**Memorandum**

TO: Hu Wen c/o PB Architects  
SITE: 8243 W Mercer Way, Mercer Island, WA 98040  
RE: Pneumatic Air Excavation Observations  
DATE: December 30, 2019  
PROJECT ARBORIST: Tyler Bunton  
ISA Certified Arborist PN-8715A  
ISA Qualified Tree Risk Assessor  
REVIEWED BY: Katie Hogan  
ISA Certified Arborist PN- 8078A  
ISA Qualified Tree Risk Assessor  
REFERENCED PLANS: Tree Plan A-1.02 (PB Architects, 10/18/19)

This memorandum documents the visit by Tyler Bunton of Tree Solutions Inc. on December 17, 2019 to the above referenced site to document the findings of exploratory pneumatic air excavation near tree 7. Peter Bocek of PB Architects requested these services to better determine the limits of disturbance and retention feasibility of tree 7, an exceptional Douglas-fir (*Pseudotsuga menziesii*) tree.

**A-1.02**  
TREE PLAN

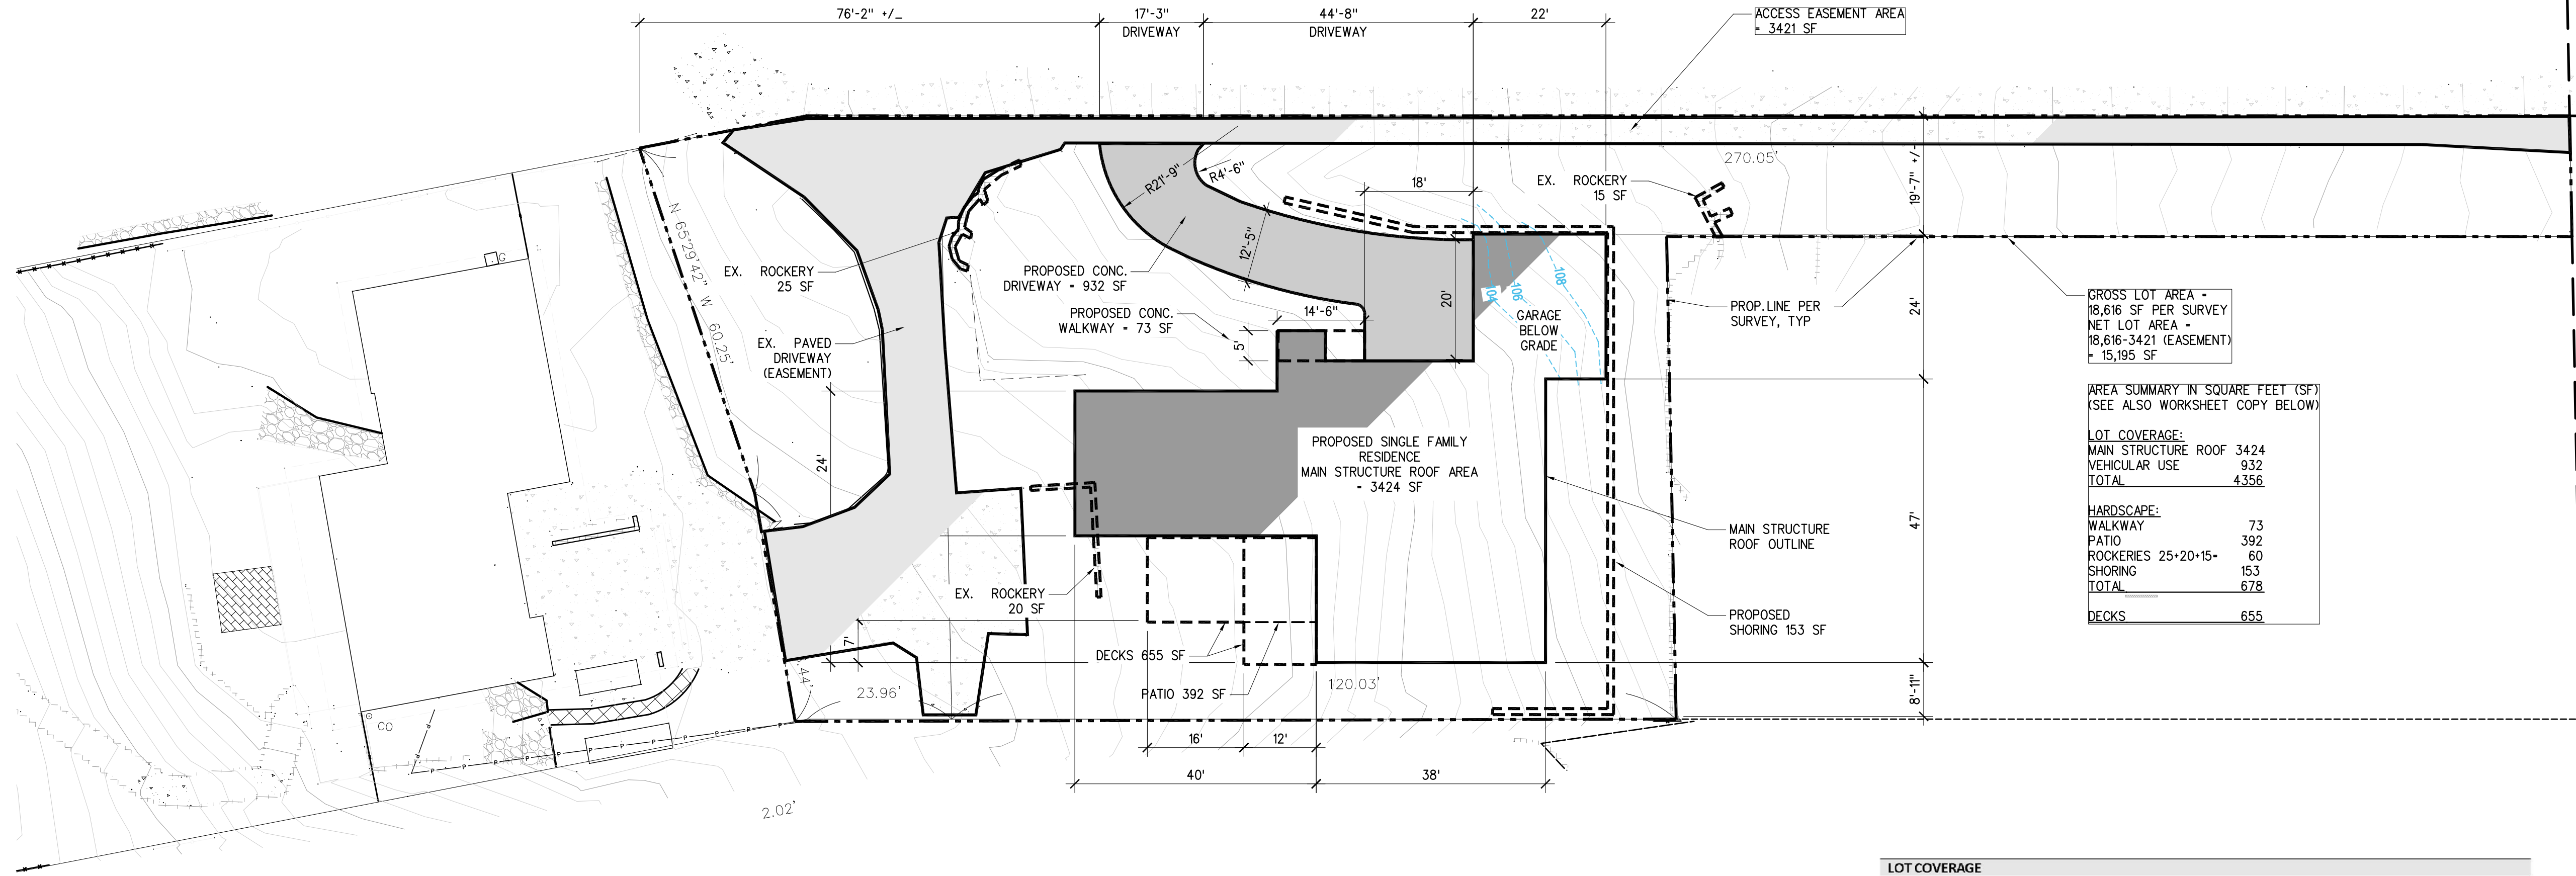
The excavation occurred to the southeast of tree 7 at the location of the proposed retaining wall to a depth of approximately 3 feet and approximately 25 feet in length centered on the tree. Three roots from tree 7 were encountered in the excavation; one 4 inch root, one 10 inch root, and one 3 inch root. In order to install the retaining wall these roots would be cut approximately 6 feet, 3 feet, and 5 feet from the base of the tree respectively.

In order to maintain the health of this tree the recommended limits of disturbance (RLOD) should be eight times the trunk diameter, which for the purposes of this memorandum will represent the critical root zone. For this 34 inch diameter tree the RLOD is 23 feet from the base of the tree. In order to maintain the stability of the tree, no root cuts should occur within the minimum limits of disturbance which is represented by a radial area of five times the trunk diameter, or 14 feet from the base of the tree. In my professional opinion cutting the roots observed for the installation of the proposed retaining wall would likely compromise the stability of the tree.
